In reply please quote: 23/29661

28 August 2024

**Request for advice: SSD-63741210 – Proposed Data Centre at 3-5 Johnson Crescent, Horsley Park**

S4-TRF-TTW-SW-DRG-0-0000-0041 CNC-2

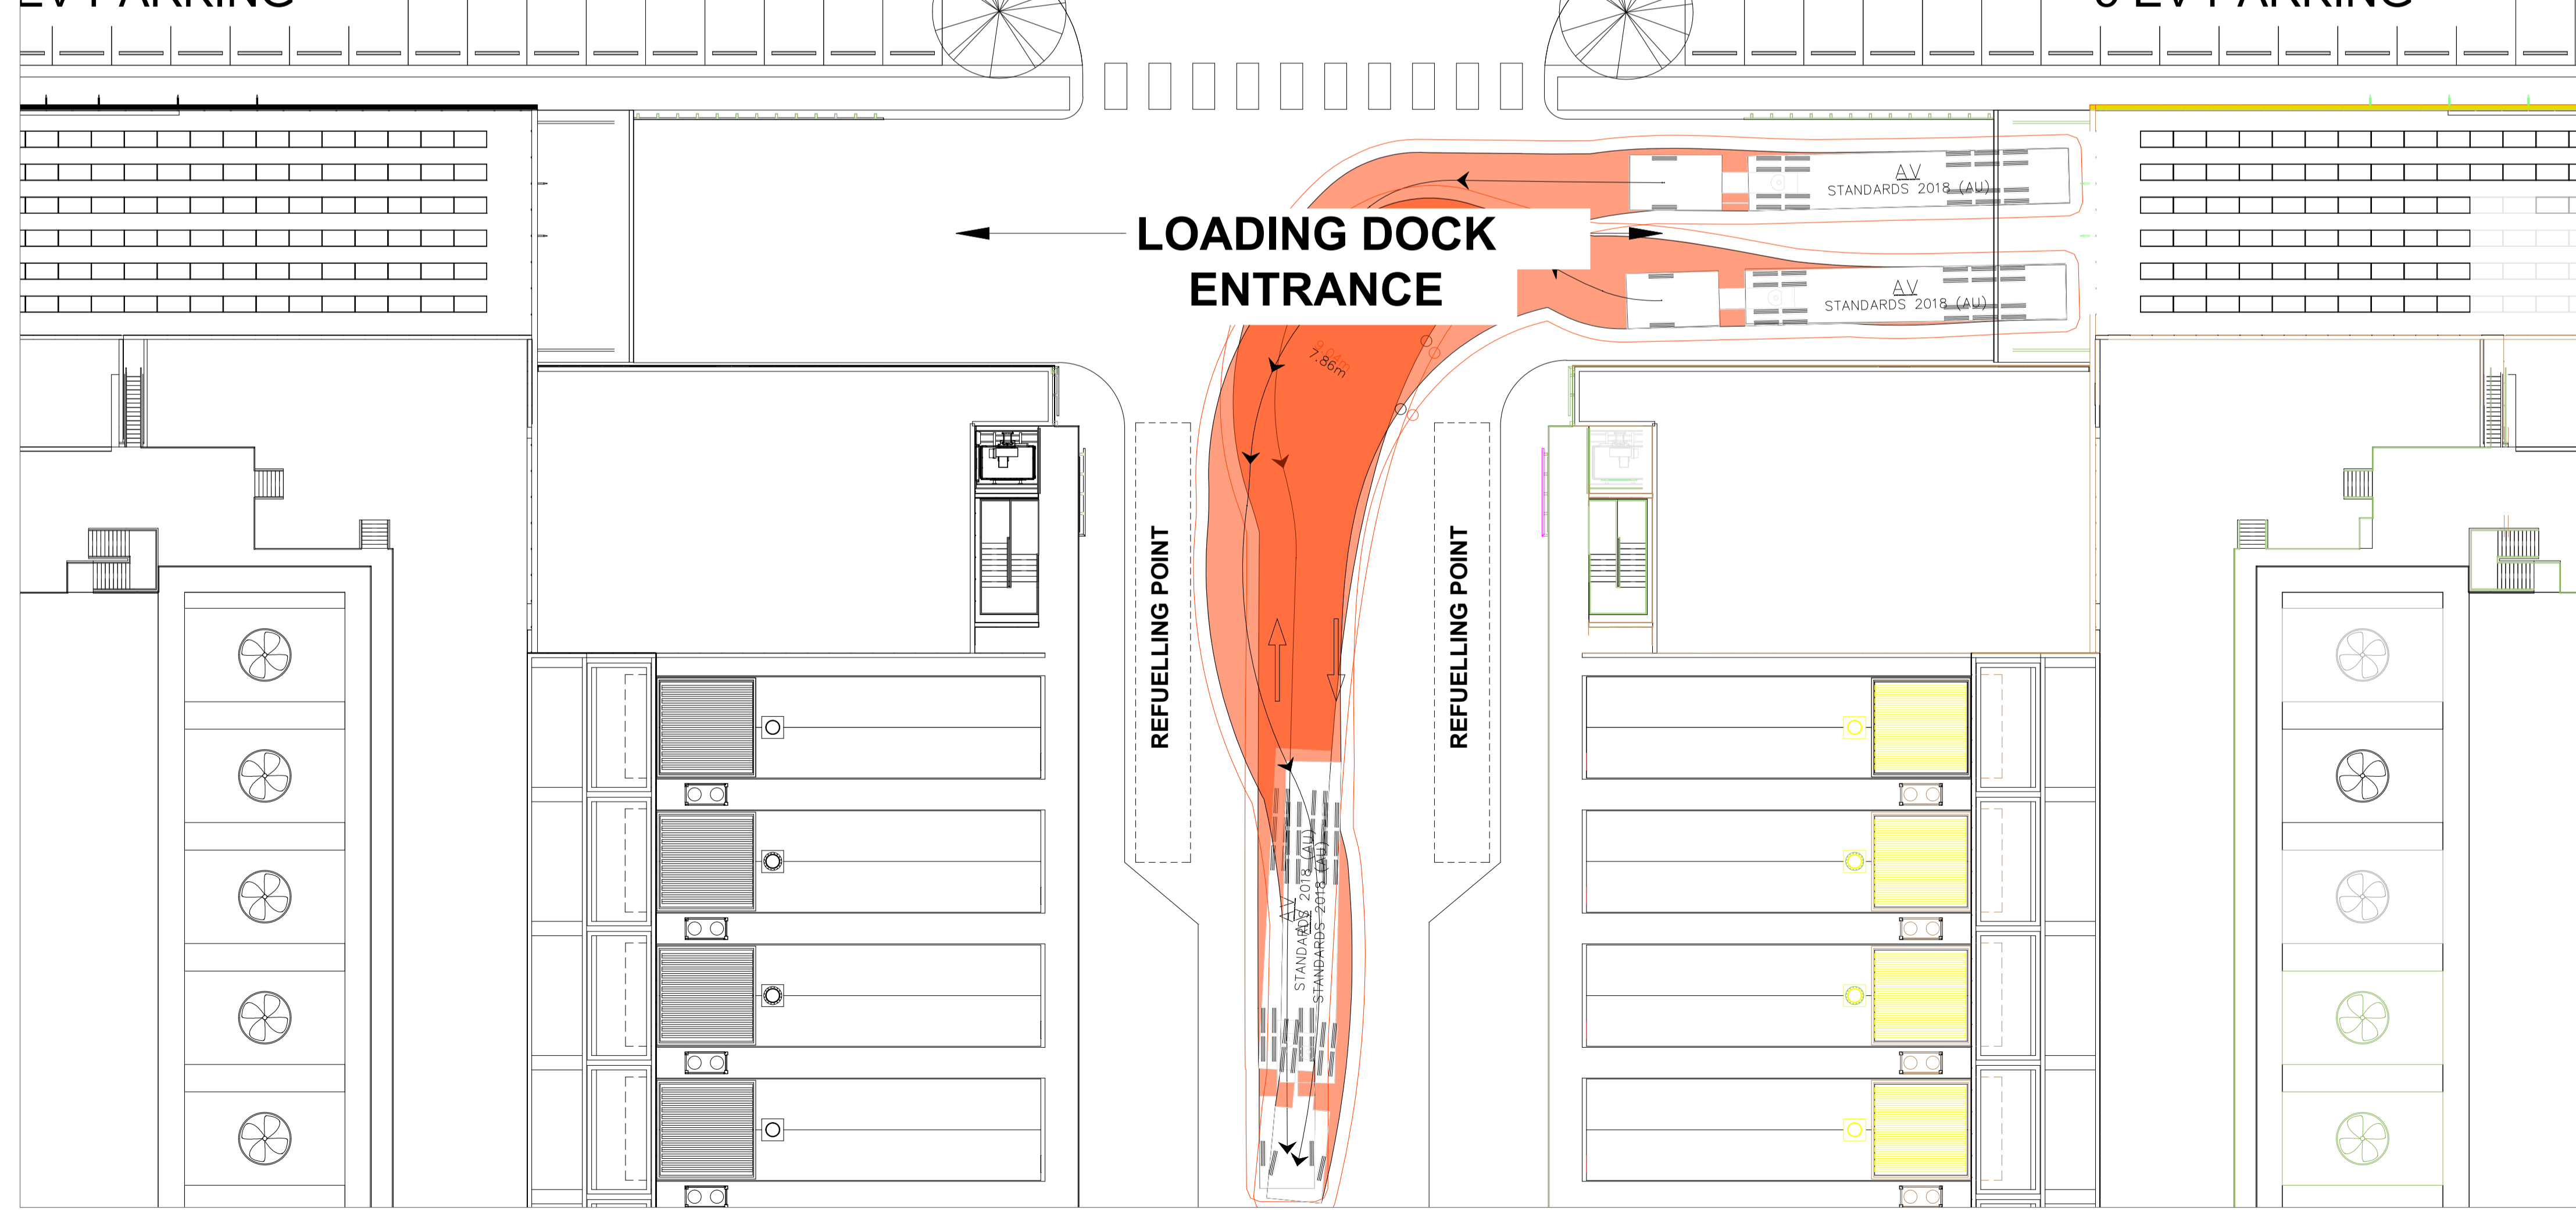
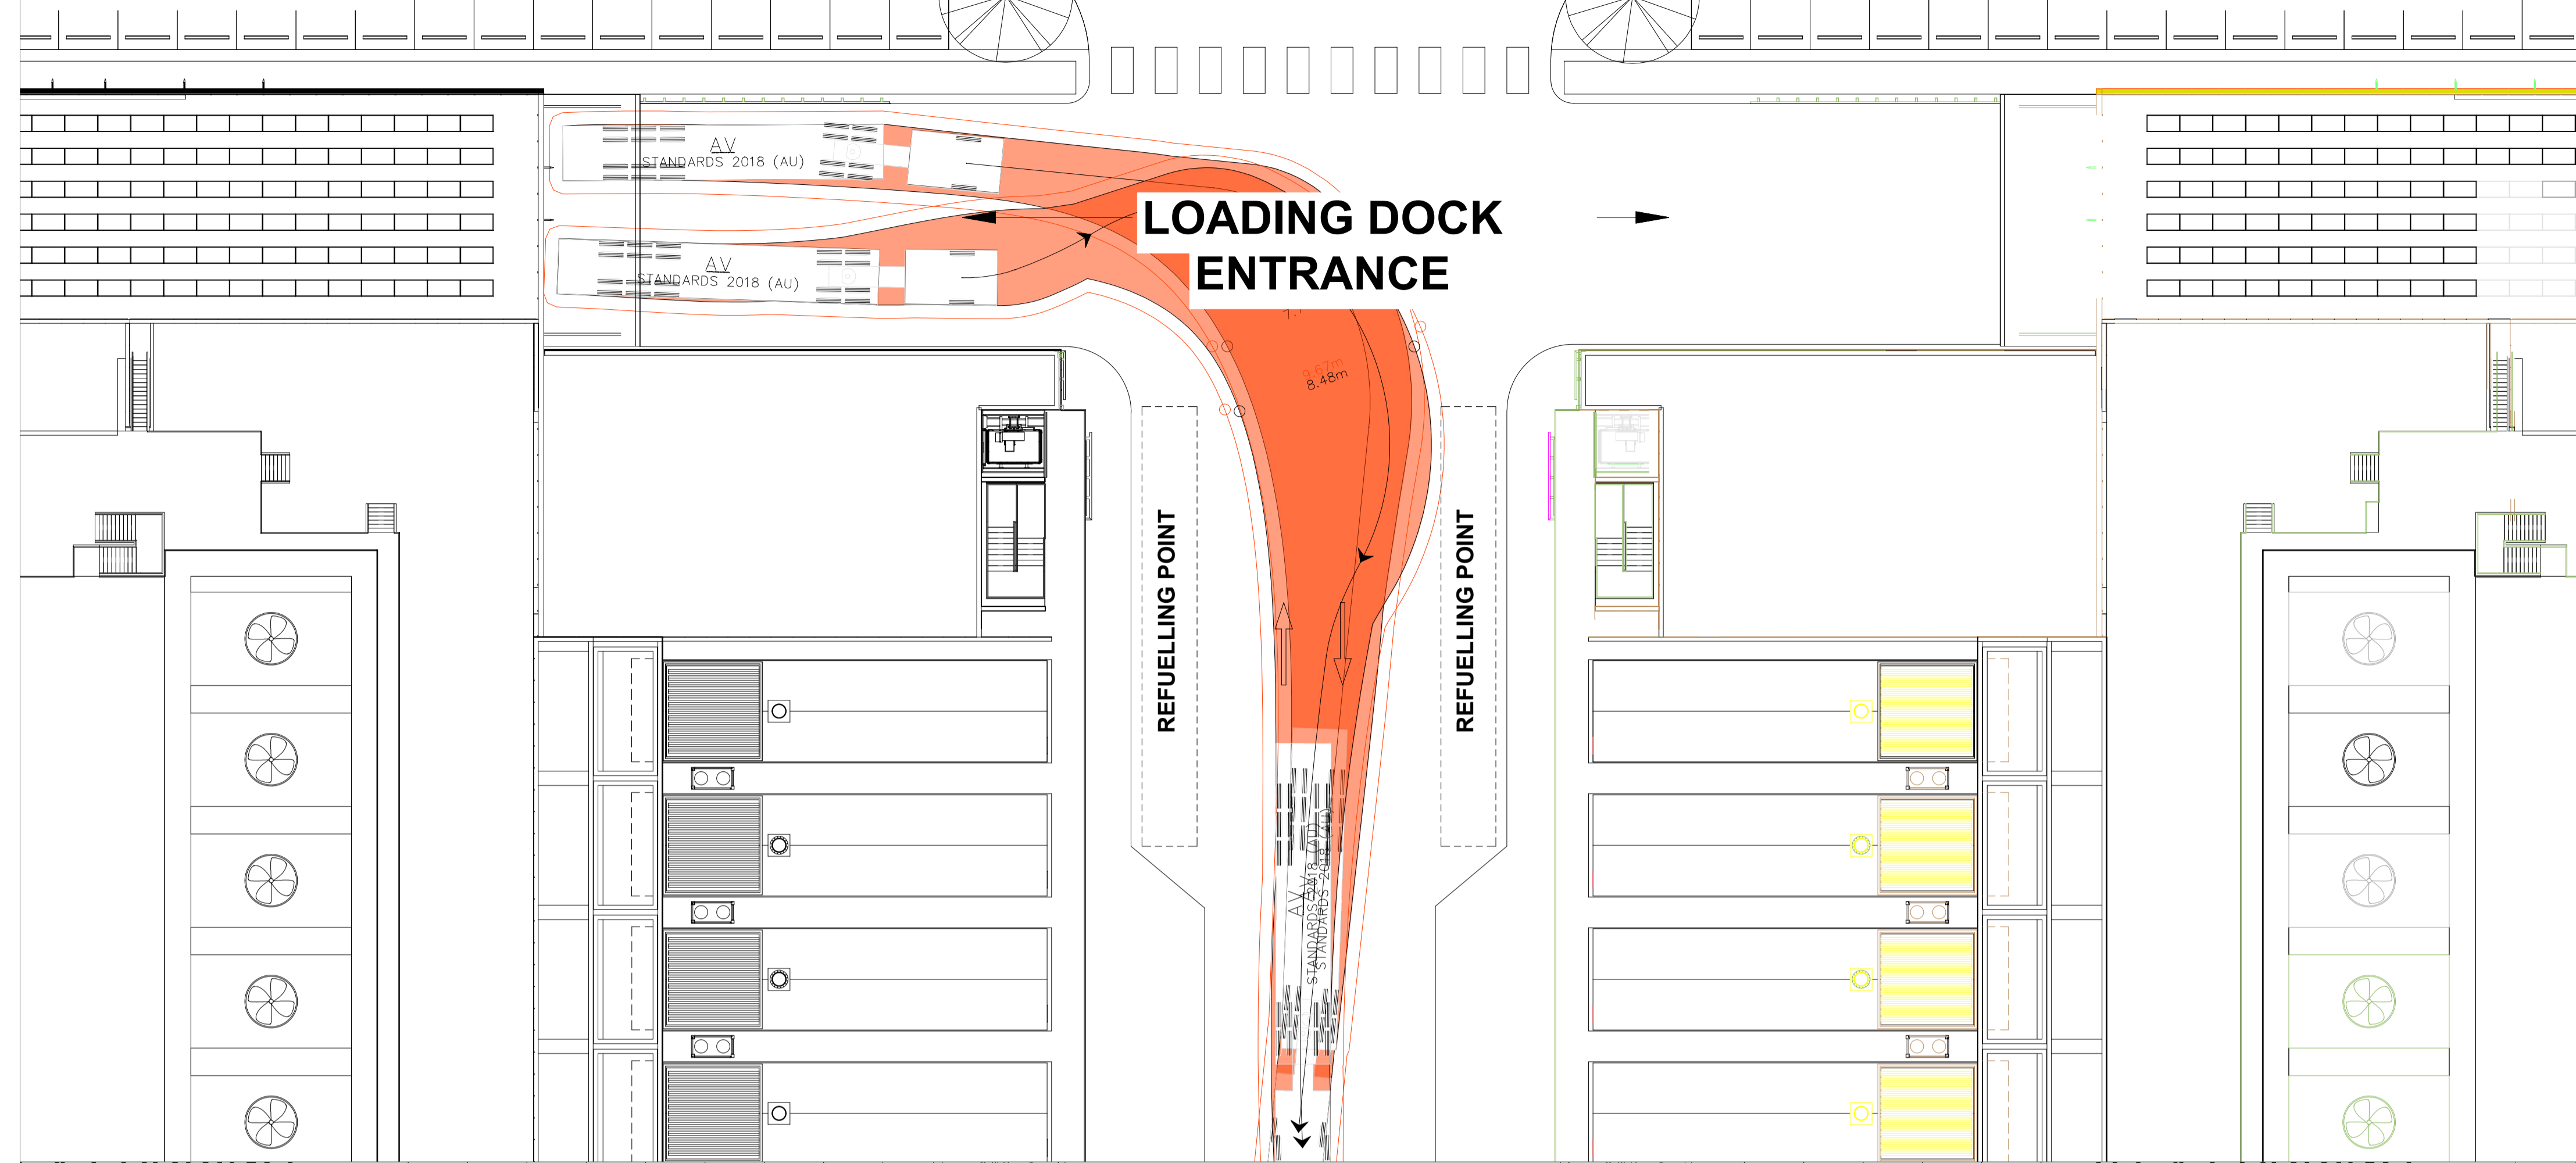
The swept path diagrams illustrate the intersection areas of the site are not adequate to accommodate the manoeuvring of a heavy vehicle and another vehicle. Further information must address the conflicts between two-way simultaneous vehicle movements at the intersections.
